Application Ref:	3/2026/0434			 Ribble Valley Borough Council www.ribblevalley.gov.uk
Date Inspected:	02/07/2026	Site Notice:	n/a	
Officer:	MC			
DELEGATED ITEM FILE REPORT:				APPROVAL

Development Description:	Variation of conditions 2 (approved plans) and 6 (parking provision) to increase the roof height of the approved garage, provide an external staircase and include 7 no. rooflights to facilitate first floor office space on planning permission 3/2025/0614 for change of use of the existing dwellinghouse (C3) to a small children's residential home (C2).
Site Address/Location:	Higher College Farm Lower Road Longridge PR3 2YY

DRG NO.	REVISION
EAD_203_P_03	S2

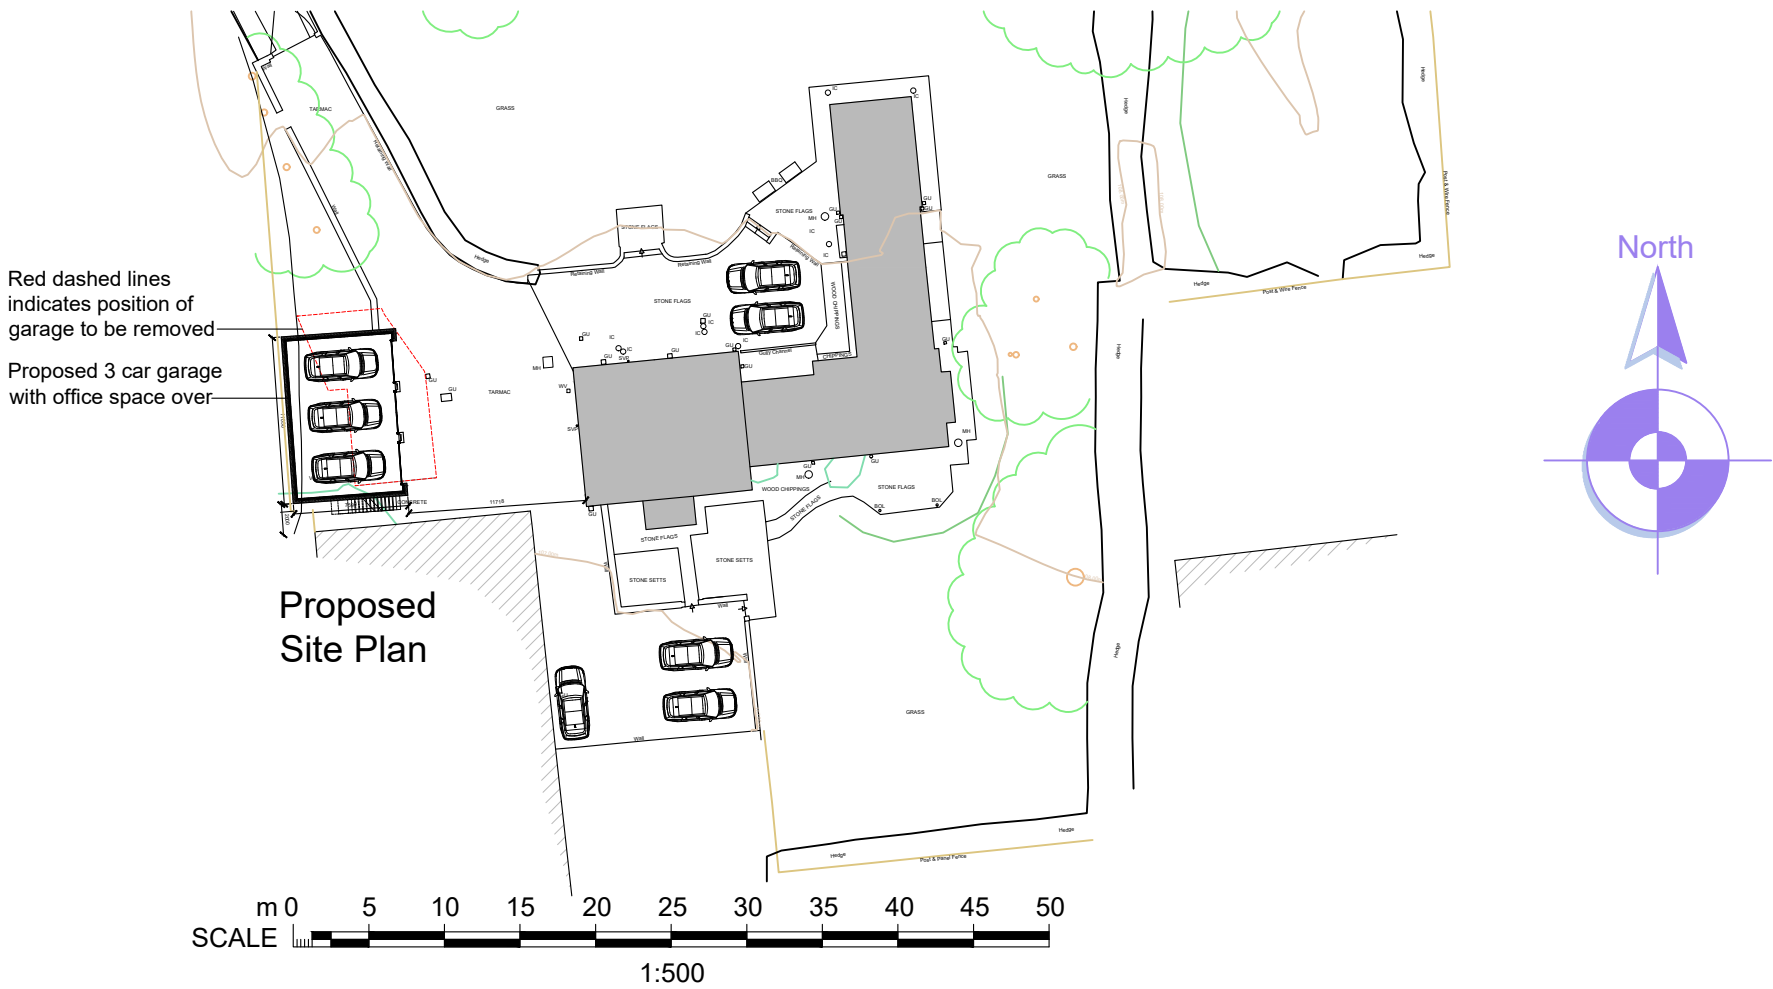
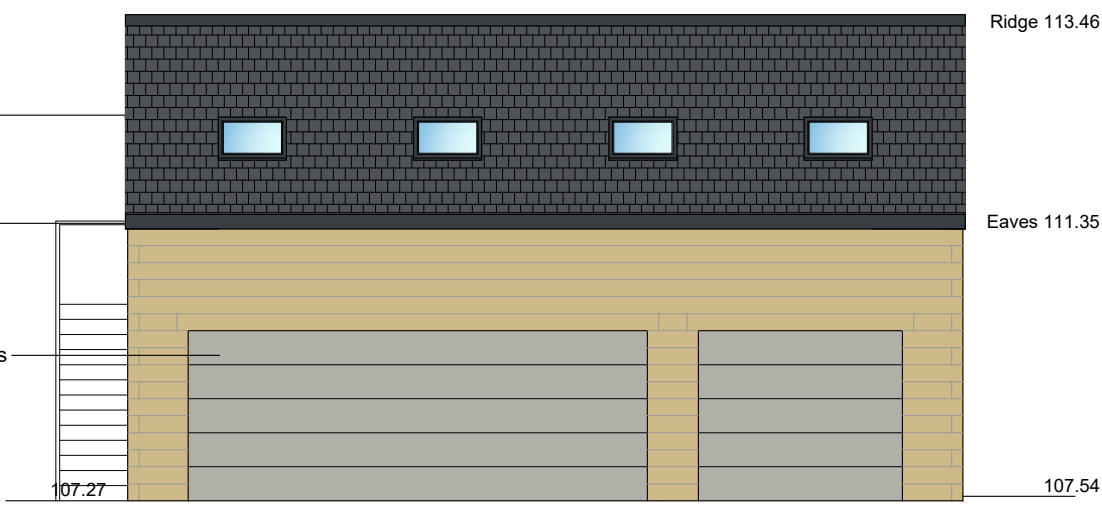
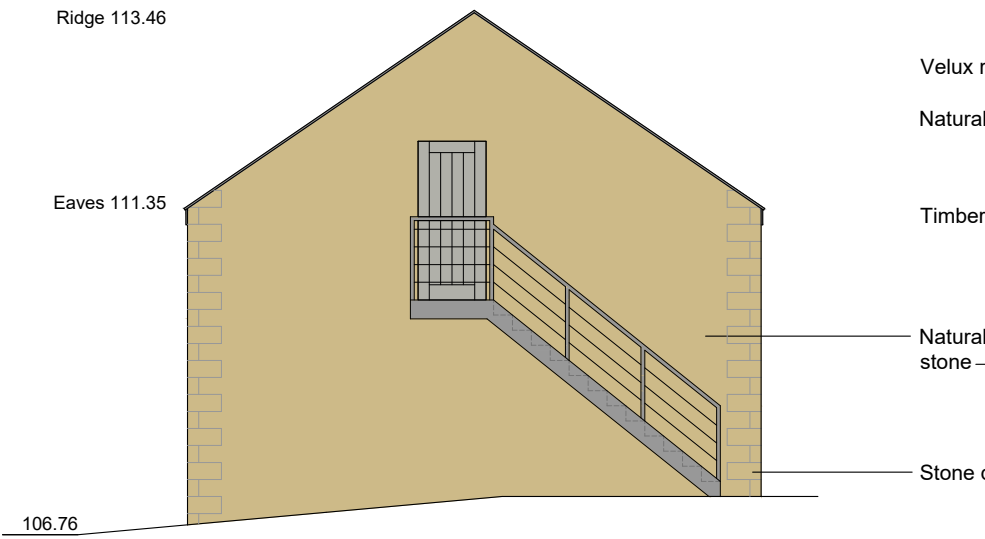
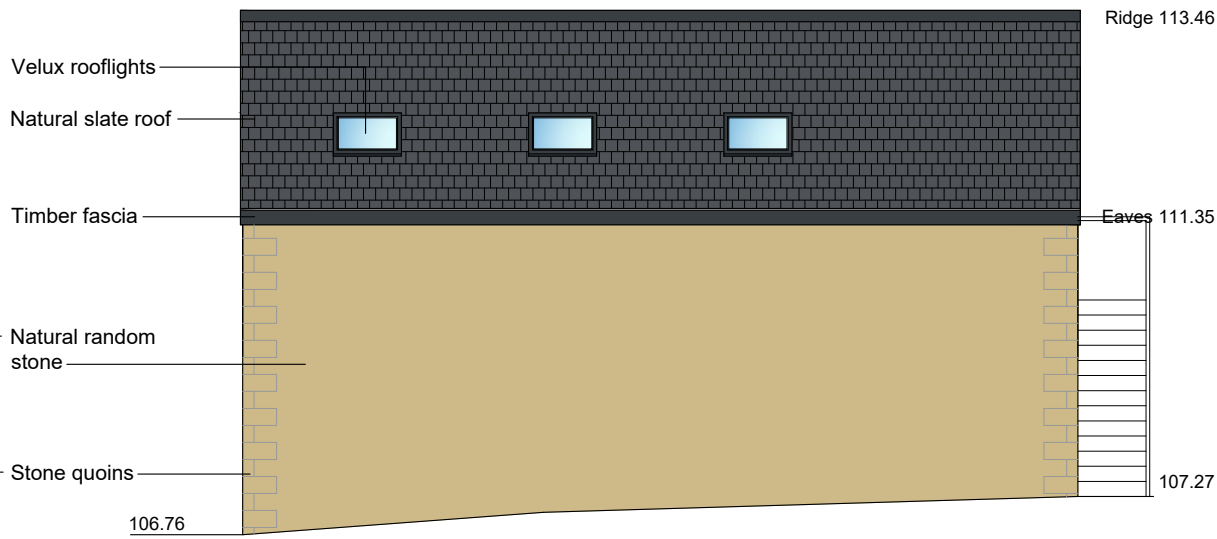
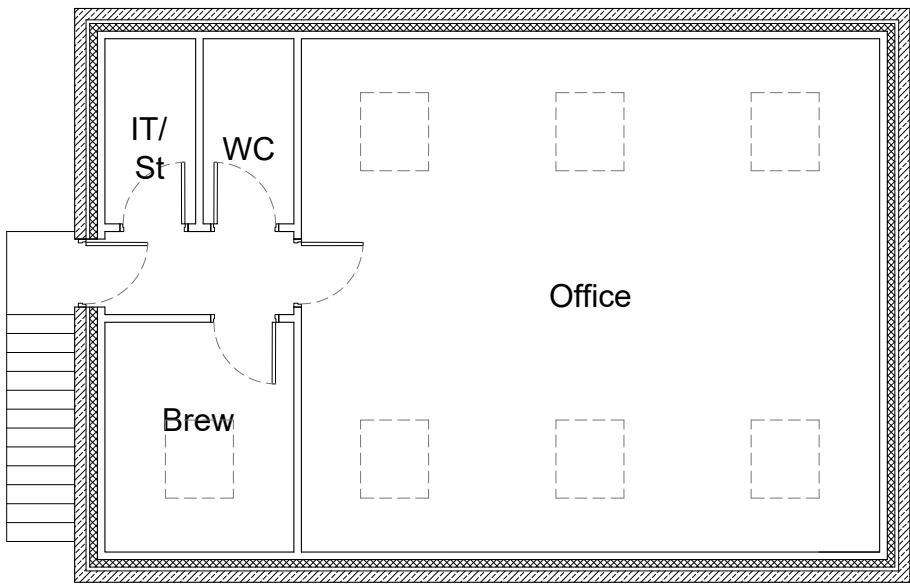
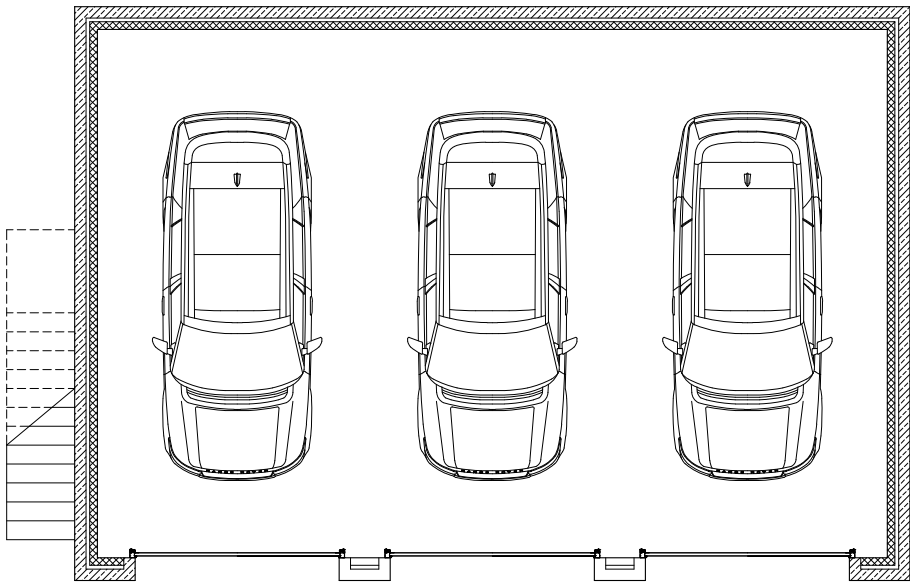
It should be noted that the proposed garage has been amended to reduce the eaves height and change the rooflights which extend down into the front elevation to 4 no. rooflights. The garage would have an eaves height of approximately 3.7m and a total height of approximately 6.4m. An external staircase would also be constructed to the side elevation.

The amended garage design is considered to now be acceptable. The Council raise no objection to the external staircase and whilst the proposed garage would be taller than the approved garage, with the eaves height being approximately 1.2m higher than the approved and the total height being approximately 1.8m taller, the height of the garage would not exceed the adjacent building and the garage would be read in the context of an ancillary outbuilding, adjacent to the three-storey main building.

The building would not be highly visible from any public vantage points and would be constructed of appropriate materials. In addition, the design of the rooflights/windows have now been amended to simple rooflights which reduces the visual prominence of the roof, when compared to the previously proposed amended.

DRG NO.  
EAD\_314\_P\_03

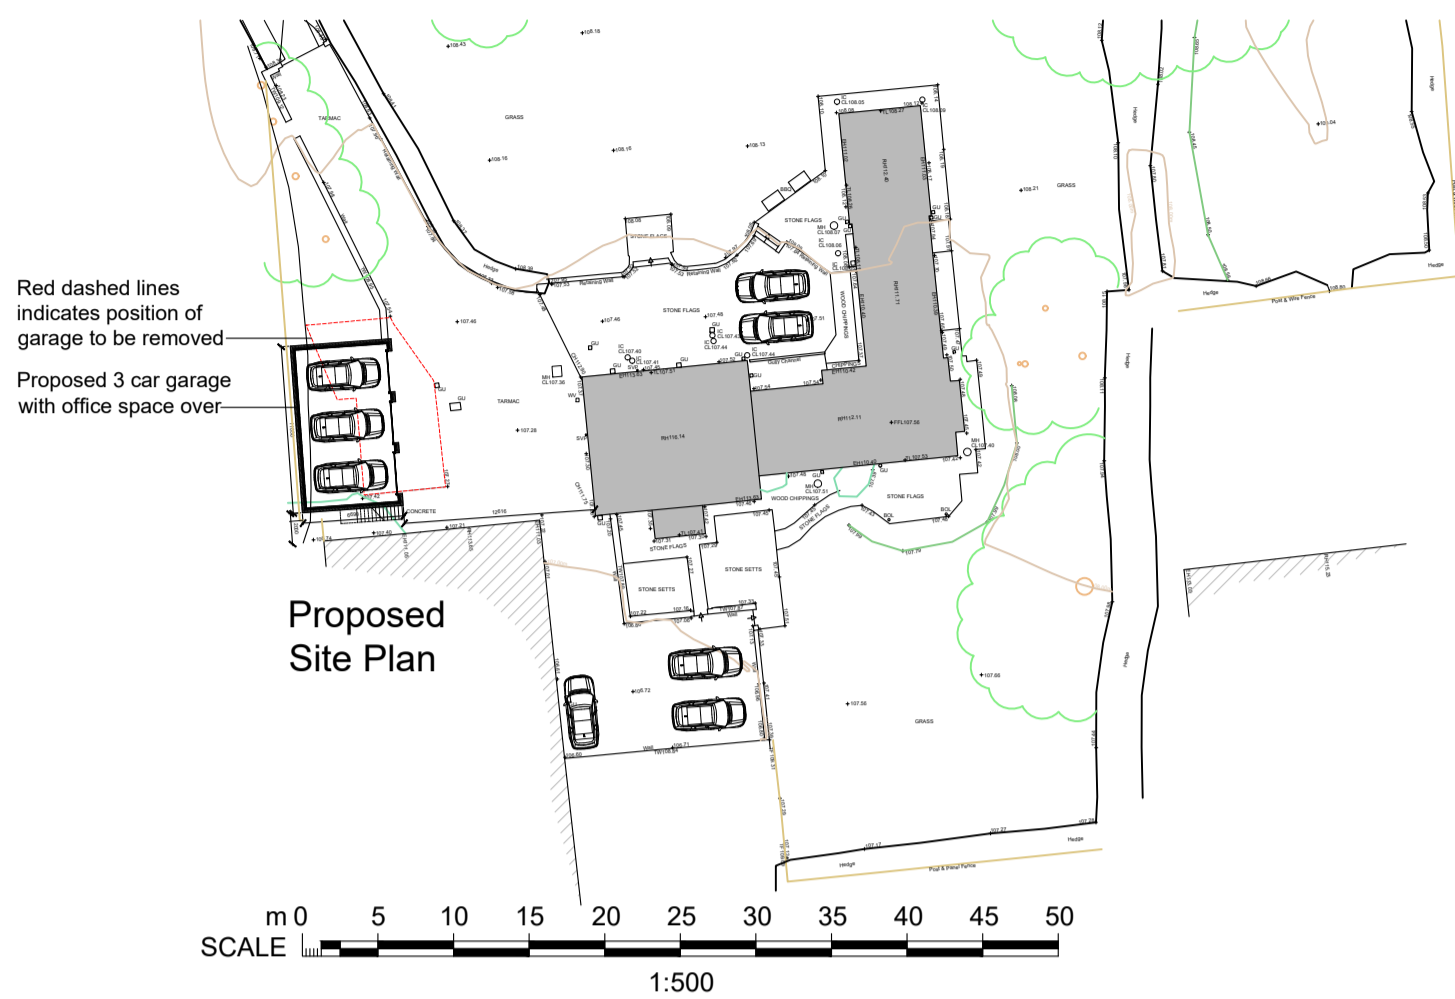
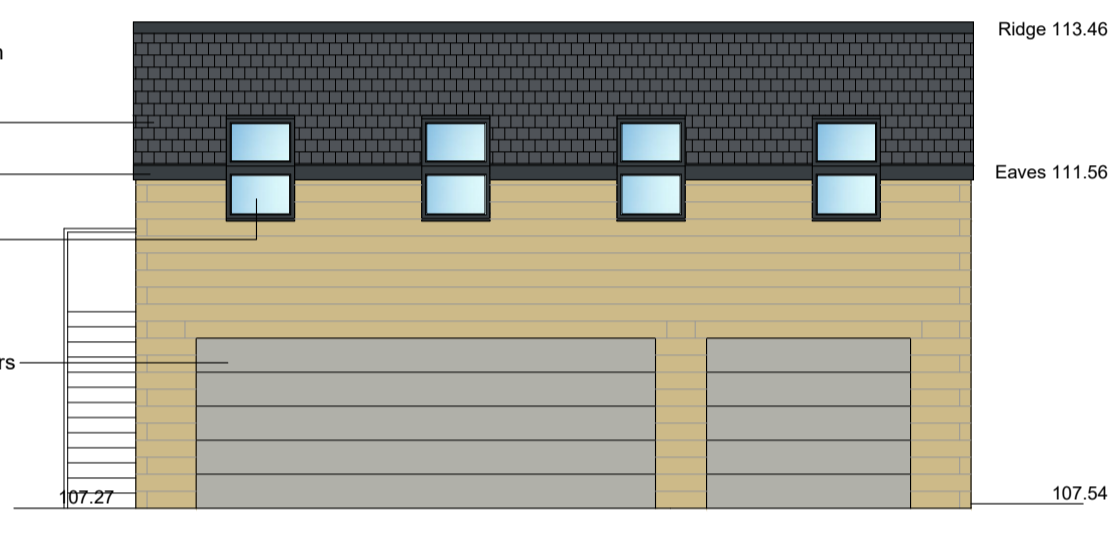
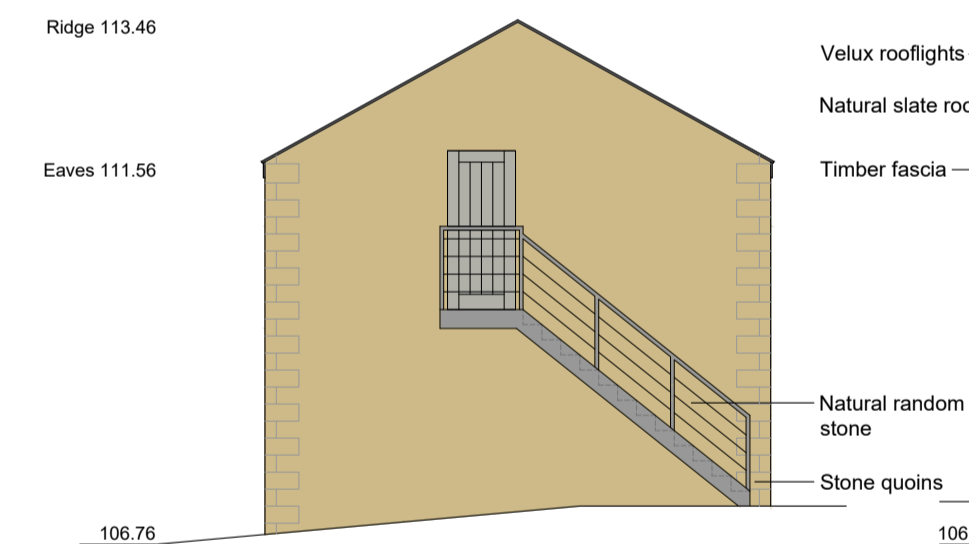
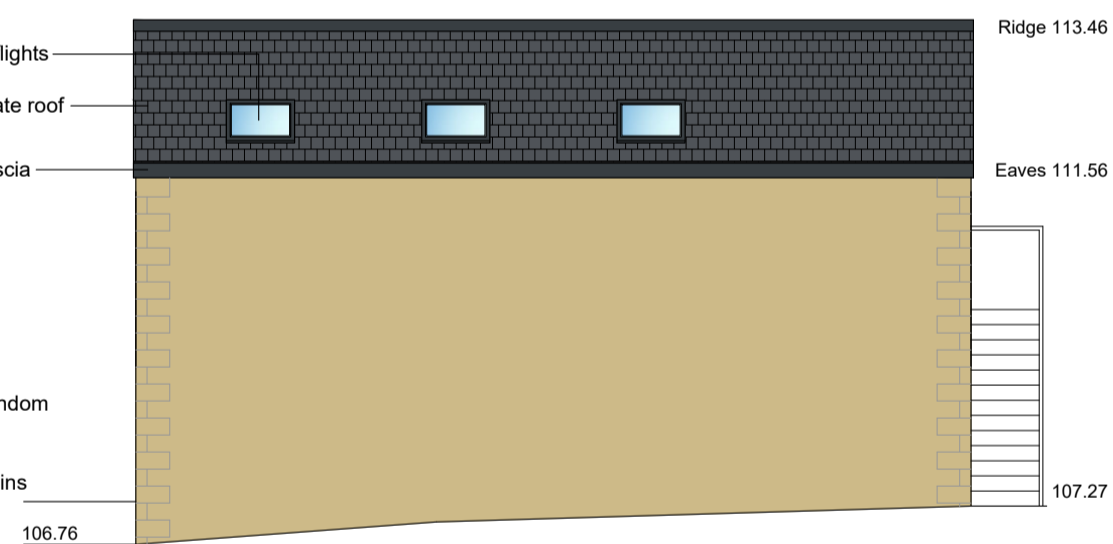
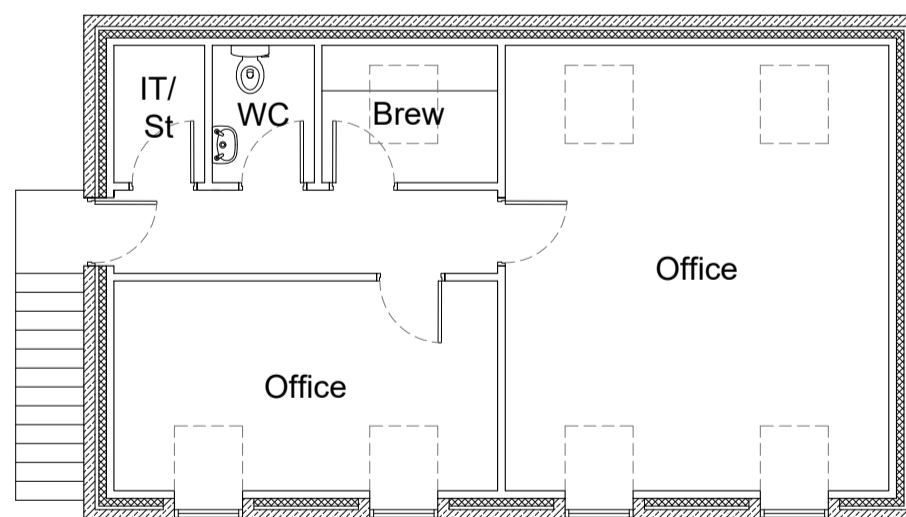
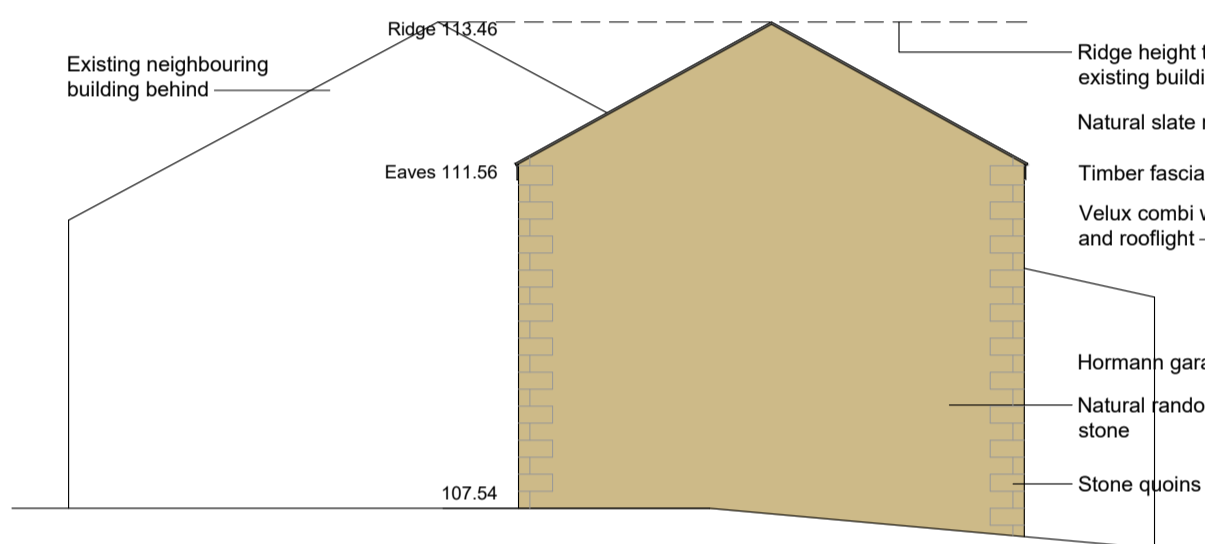
CONSULTATIONS:	Highways/Water Authority/Other Bodies
LCC Highways:	The LHA has no objection to the variation of conditions 2 and 6 on planning permission 3/2025/0614. The LHA has reviewed drawing EAD_314_P_03 and notes that the parking is at the same provision level as the approved scheme under application 3/2025/0614. The proposed garage meets the recommended minimum internal dimensions for a garage which can support 3 car parking spaces. It is noted that the proposed office space is for the provision of a dedicated area for staff to undertake administrative tasks in a space which is separated from the main living accommodation, and as such will not change the use which has been approved under application 3/2025/0614.
CONSULTATIONS:	Additional Representations.
No additional representations received.

The Local Planning Authority (LHA) have provided comments on the scheme and they raise no objection to the variation of conditions 2 and 6 on planning permission 3/2025/0614. The parking provision would remain as approved and the proposed garage meets the recommended minimum internal dimensions for a garage which can support 3 car parking spaces. It is noted that the proposed office space is for the provision of a dedicated area for staff to undertake administrative tasks in a space which is separated from the main living accommodation, and as such will not change the use which has been approved under application 3/2025/0614.
